M60/M62/M66 Simister Island Interchange

TR010064

7.18 Statement of Common Ground with Bury Council

Version	Date	Status of Version
P02	10 January 2025	Examination Deadline 5

FIGURE 5.10

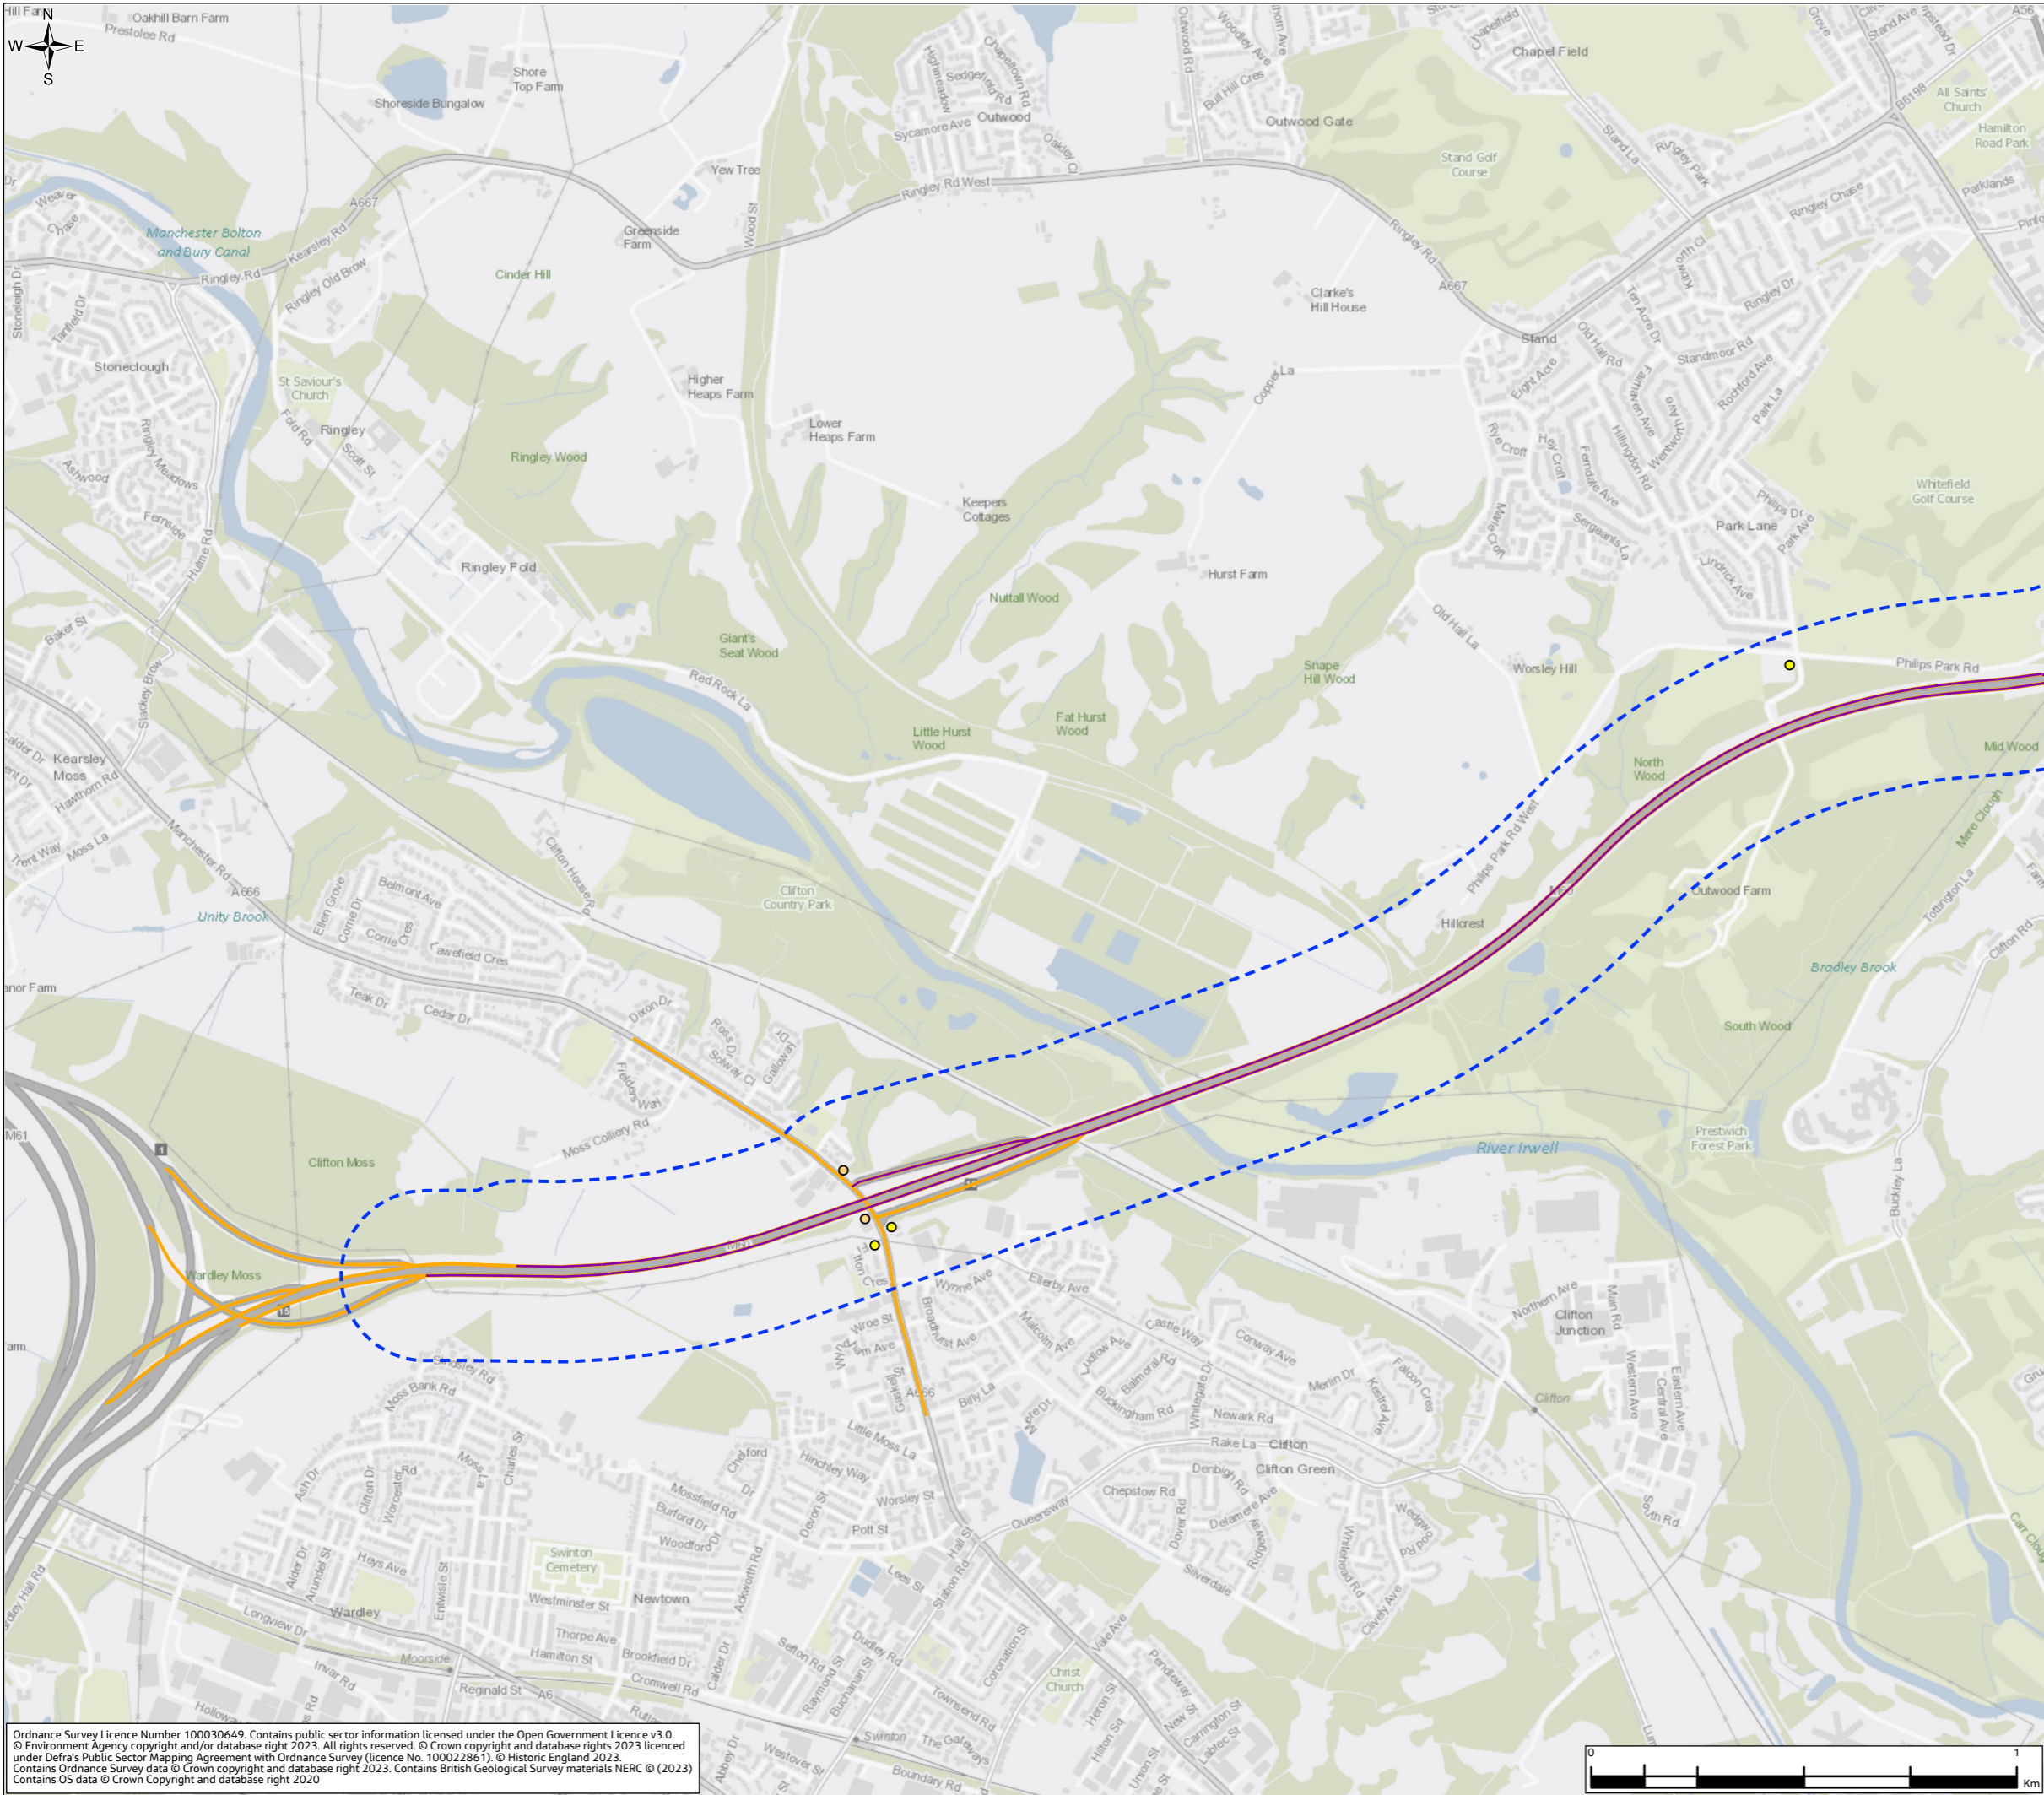
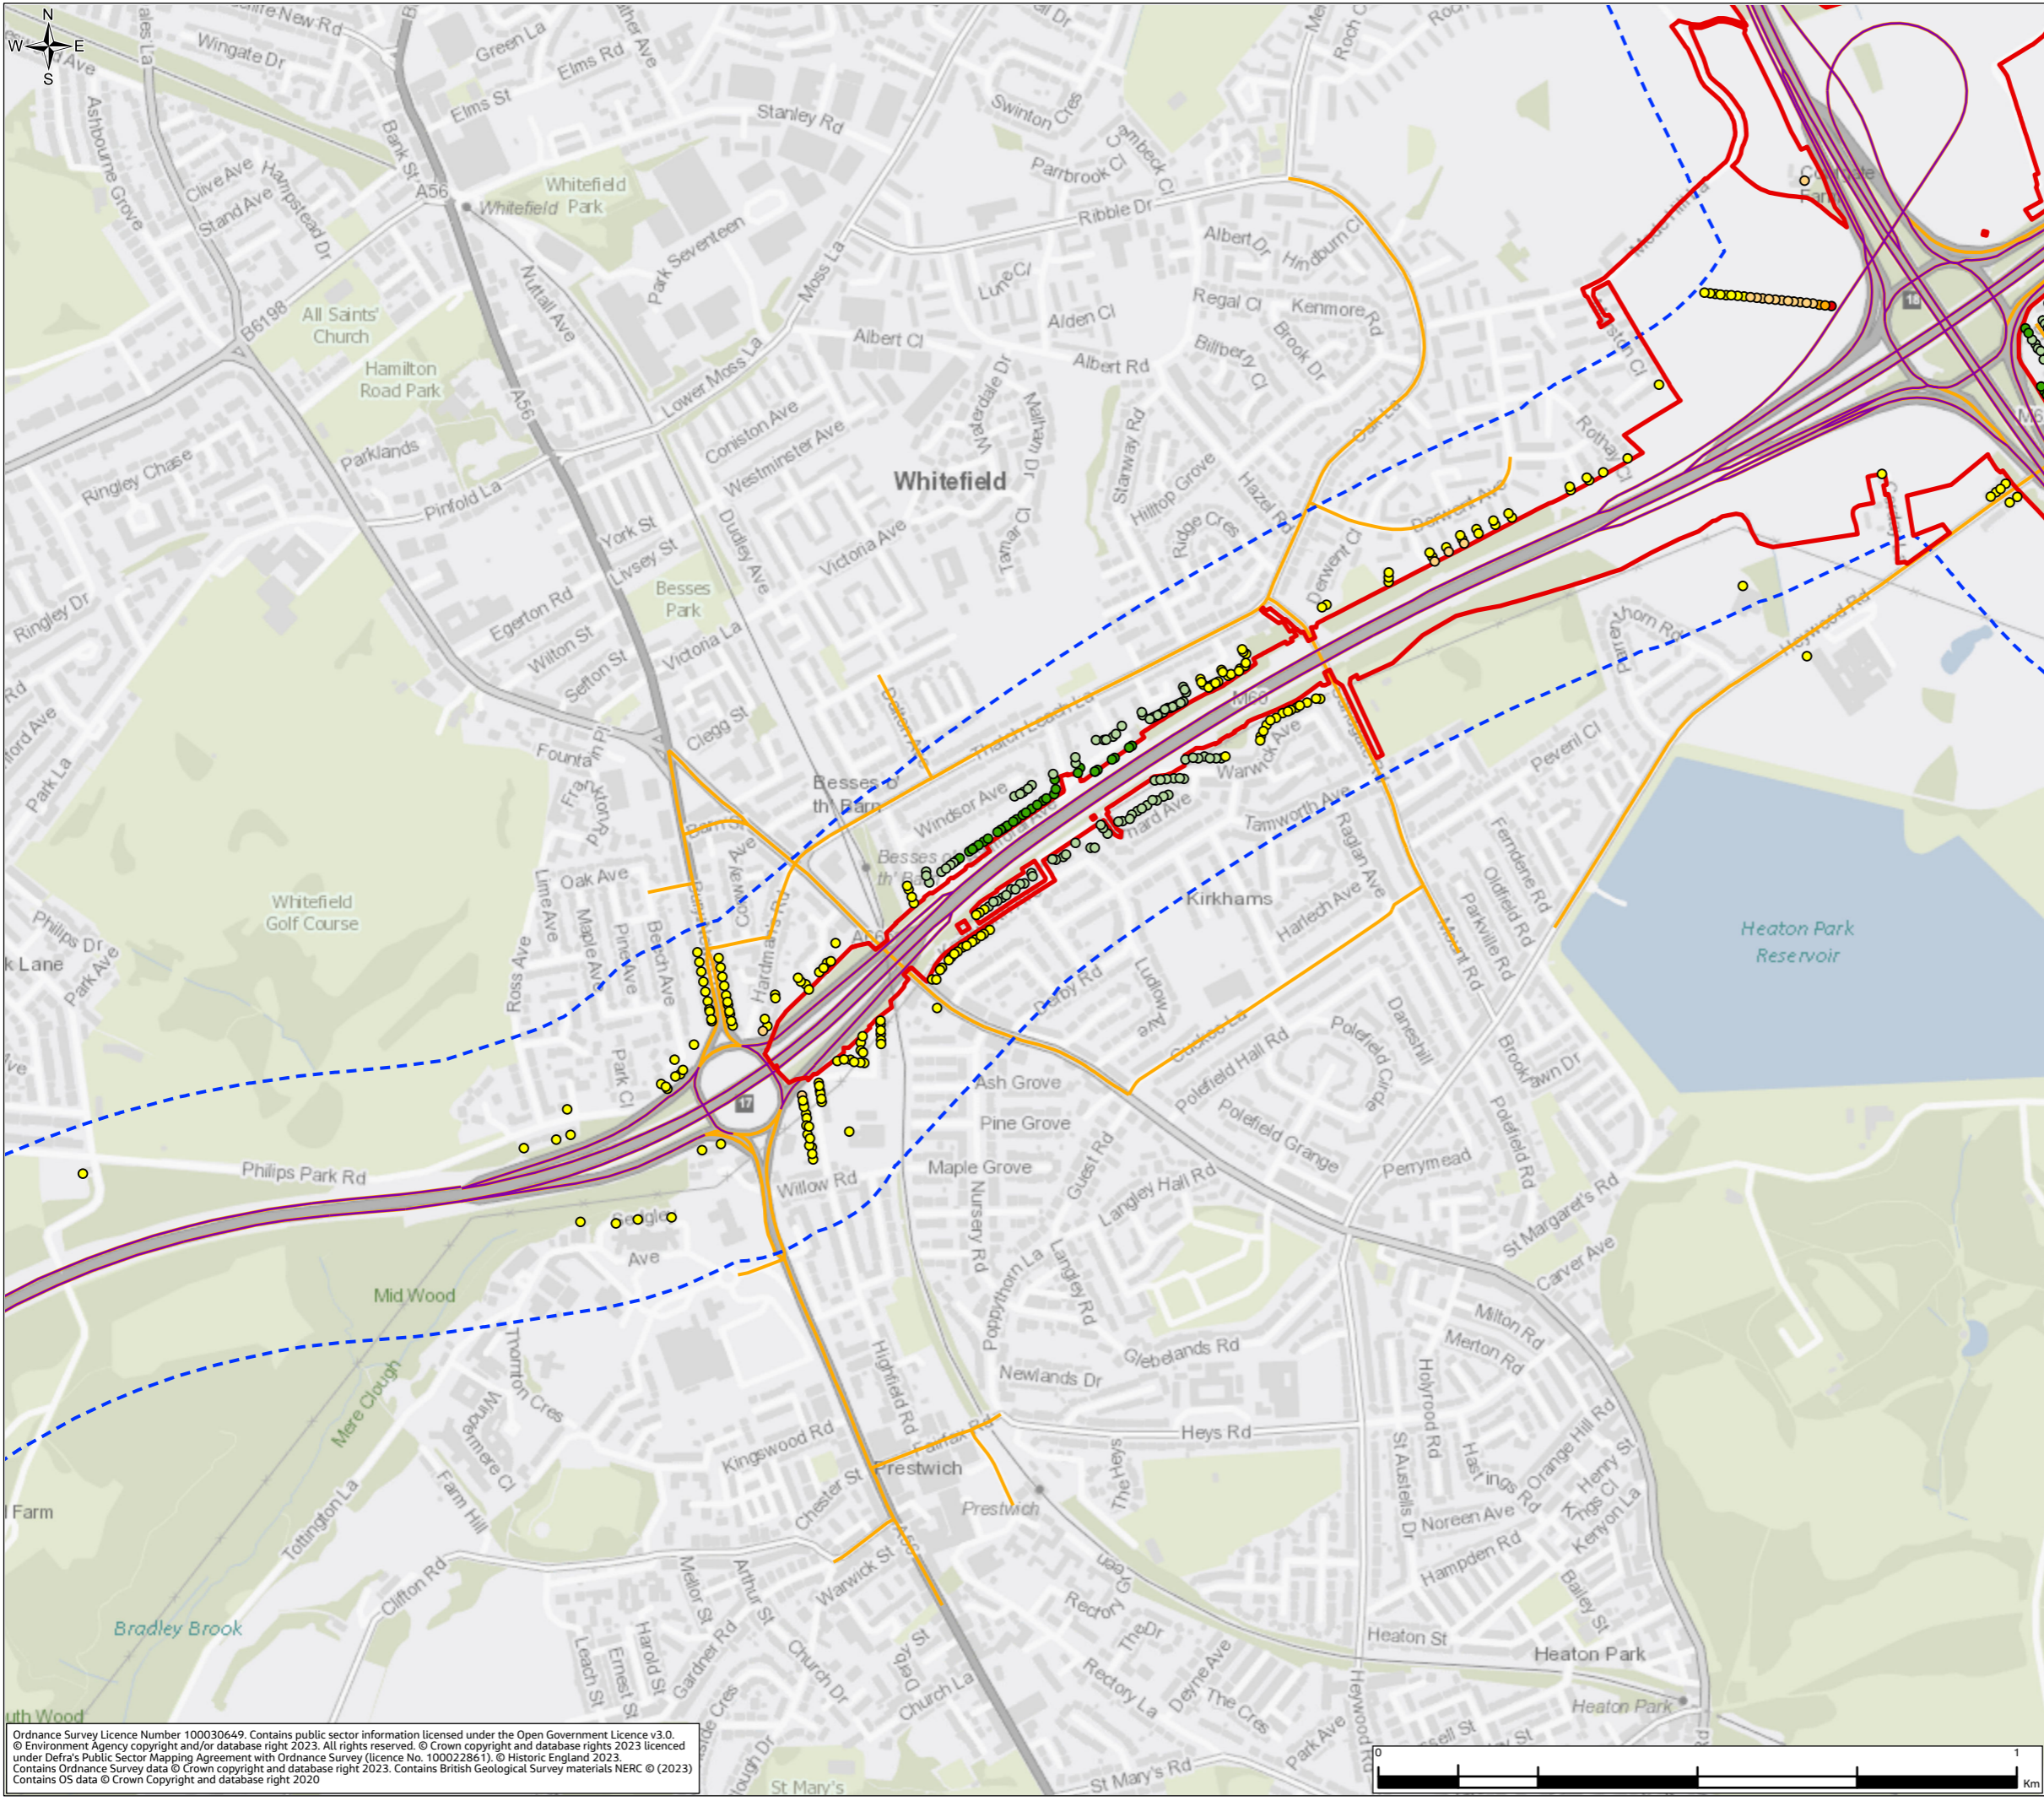
4	Operational Phase Air Quality Impacts	Chapter 5: Air Quality of the Environmental	Bury Metropolitan Borough Council reviewed the results of the operational traffic assessment presented in Appendix 5.2: Air Quality Results [APP-	The Applicant notes Bury Metropolitan Borough Council comments on the findings and conclusions of the	No	Not Agreed	26/09/24

Ref	Issue	Doc Ref	Bury Metropolitan Borough Council Position	National Highways' Position	Agreement Likely	Status	Date
		<p>Statement [APP-045]</p> <p>Appendix 5.2: Air Quality Results [APP-080] of the Environmental Statement Appendices</p> <p>Chapter 5: Air Quality (Figures 5.10-5.11) [APP-061] of the Environmental Statement Figures</p> <p>draft Development Consent Order [REP1-004].</p>	<p>080] of the Environmental Statement Appendices and Chapter 5: Air Quality (Figures 5.10-5.11) [APP-061] of the Environmental Statement Figures. Based on the information provided, the findings and conclusions of the operational phase traffic risk assessment appear reasonable.</p> <p>Bury Metropolitan Borough Council note that the assessment concludes that the operational phase will improve air quality. In order to demonstrate that the predicted improvements in air quality have been achieved, A programme of air quality monitoring (for NO2) should be undertaken once the Scheme is operational to demonstrate that the predicted improvements in air quality have been achieved.</p> <p>Bury Metropolitan Borough Council notes the Applicant's position that there are no identified significant effects for air quality for the Scheme, as set out in paragraph 5.11.1 of the Chapter 5 Air Quality of the Environmental Statement [APP-044], there is no requirement to undertake future air quality monitoring where the assessment concludes no significant effects.</p> <p>Bury Metropolitan Borough Council also notes that the traffic flow monitoring to be carried out as part of the Post</p>	<p>operational phase traffic risk assessment.</p> <p>Chapter 5 Air Quality of the Environmental Statement [APP-044] discusses the air quality assessment and concludes that there would be no significant effects, due to air quality, during construction and operation of the Scheme from road traffic changes. The assessment of significant effects is based on the Design Manual for Roads and Bridges (DMRB) LA 105 (Air quality) definitions, which are explained in Chapter 5 Air Quality of the Environmental Statement [APP-044]. Closer to the Scheme, between M60 junction 17 and M60 junction 18 and around Simister, there is generally a reduction in air pollution concentrations (i.e., an improvement in air quality) with the Scheme in place. This reduction is due to either reduced congestion between M60 junction 17 and M60 junction 18 or, for Simister, due to traffic using the Northern Loop slip road (i.e., some traffic is moved further away).</p> <p>In response to Bury Metropolitan Borough Council's request for a programme of air quality monitoring, the Applicant notes that some schemes with predicted significant effects in relation to air quality undertake monitoring to</p>

Ref	Issue	Doc Ref	Bury Metropolitan Borough Council Position	National Highways' Position	Agreement Likely	Status	Date
			<p>Opening Project Evaluation (POPE) process to determine whether predicted flow rates were realistic could also be used to assess whether the predicted air quality impacts were accurate. However, we still consider that carrying out a programme of diffusion tube (NOx) monitoring would be a positive action to demonstrate to concerned local residents that local air quality had not been significantly worsened by the Scheme and that the predicted impacts of the Scheme were accurate. It is understood that the Applicant already monitors in certain locations within the vicinity of the motorway network and we do not consider that the extending this diffusion tube monitoring network would be an onerous requirement. This issue is not agreed.</p>	<p>assess compliance against Air Quality Objectives and/or Limit Values. However, as discussed in paragraph 5.11.1 of the Chapter 5 Air Quality of the Environmental Statement [APP-044], as there are no identified significant effects for air quality for the Scheme, there is no requirement to undertake future air quality monitoring. It should be noted that it is very difficult to prove the impact of a scheme, by itself, on air quality by monitoring future air quality. This is due to the typical year-to-year variations that occur due to differing conditions such as wind speed and direction, as well as year to year changes in vehicle emissions, which are changes not related to the Scheme. Typically, the impact on air quality from a scheme is assessed under the Post Opening Project Evaluation (POPE) process, which is undertaken on all major road schemes once it has been operational for one year and again 5 years post-opening. Other schemes under POPE have used monitored road traffic flows and speeds before and after a scheme is opened, to calculate a scheme-only change to emissions which are due to changes in traffic (as opposed to air quality changes due to metrological conditions or changing vehicle emissions).</p>
